Tel: 01903 737756
Email: planning@arun.gov.uk
www.arun.gov.uk/planning
Please ask for: Ms Iqraa Malik
Email: iqraa.malik@terraquest.co.uk
Telephone: 0121 234 1390
Our Ref: A/59/26/HH
Your Ref:
Date: 14th May 2026

Application for Planning Permission for Works or Extension to a Dwelling

Development: Demolition of existing conservatory and construction of a single storey mono-pitched roof extension.
Location: 115 Downs Way East Preston BN16 1AD

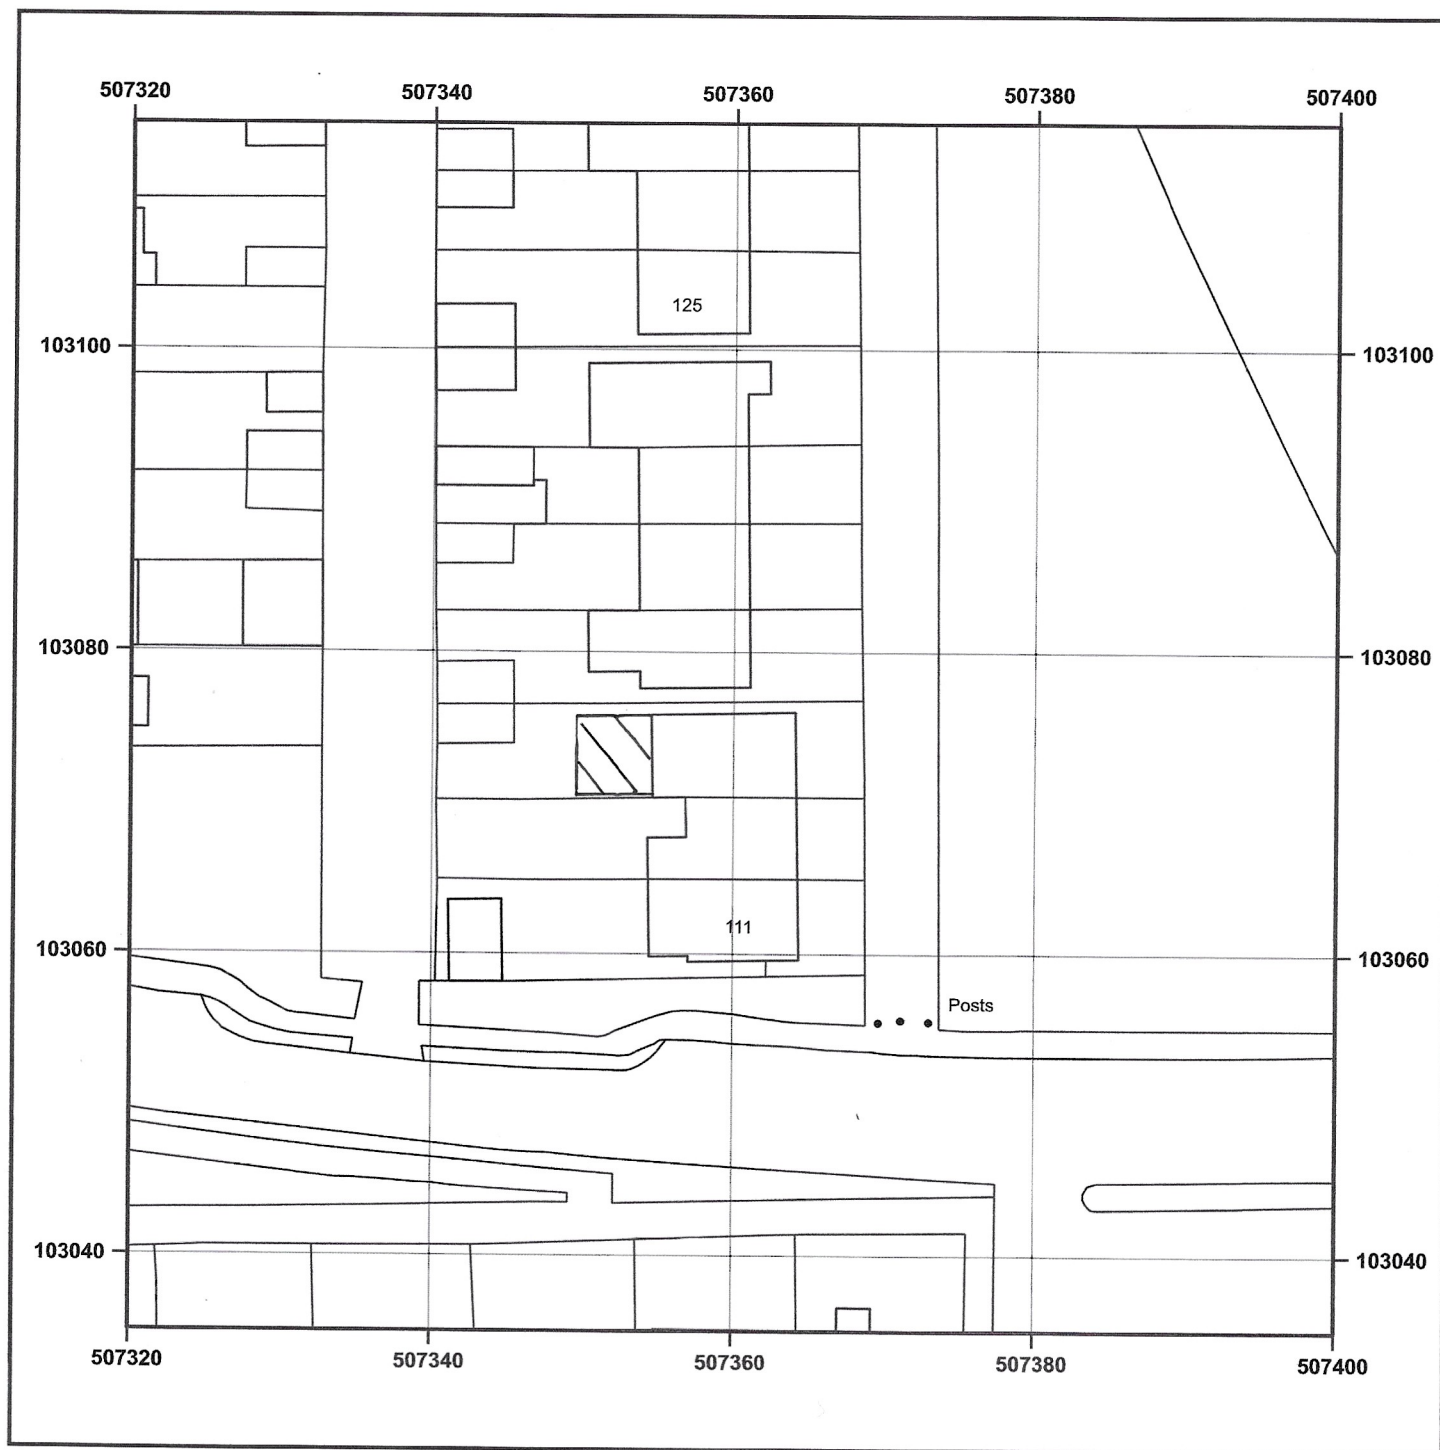
Block Plan

You are required to have dimensions from the proposed extension(s) to all site boundaries. Please amend

PROPOSED SIDE ELEVATION (NORTH)

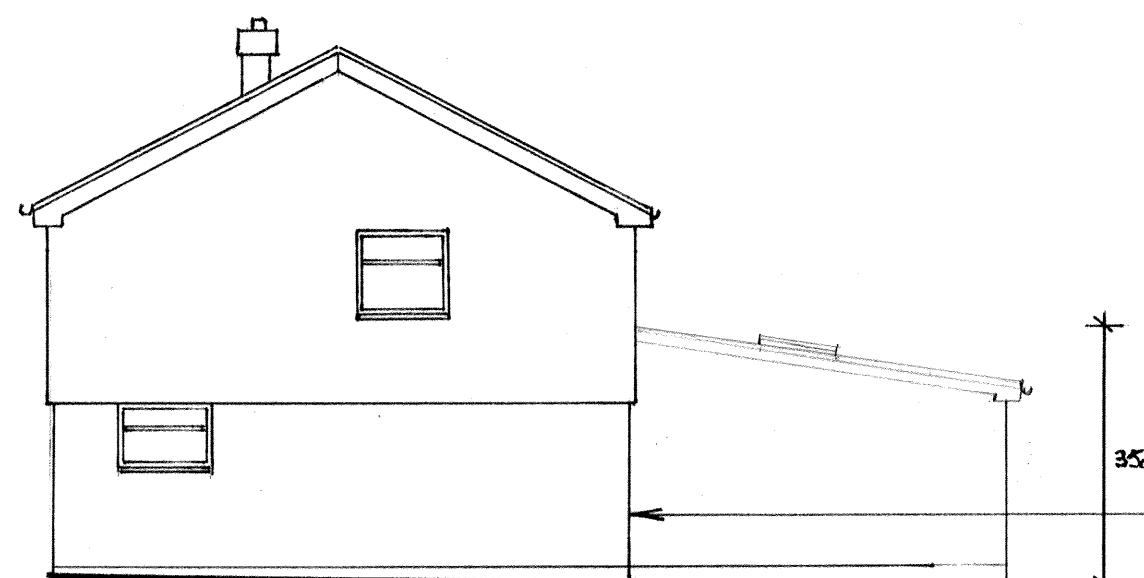
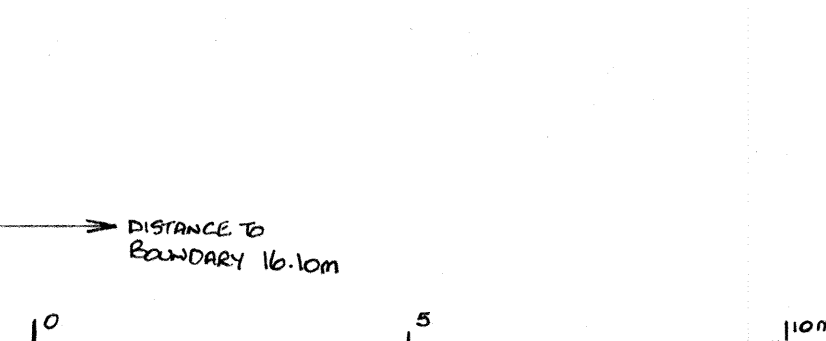
Elevations

Please submit electronic plans in pdf format clearly labelled proposed other side elevation at a scale of 1:50 or 1:100. Further details can be found in the Validation Requirements List.
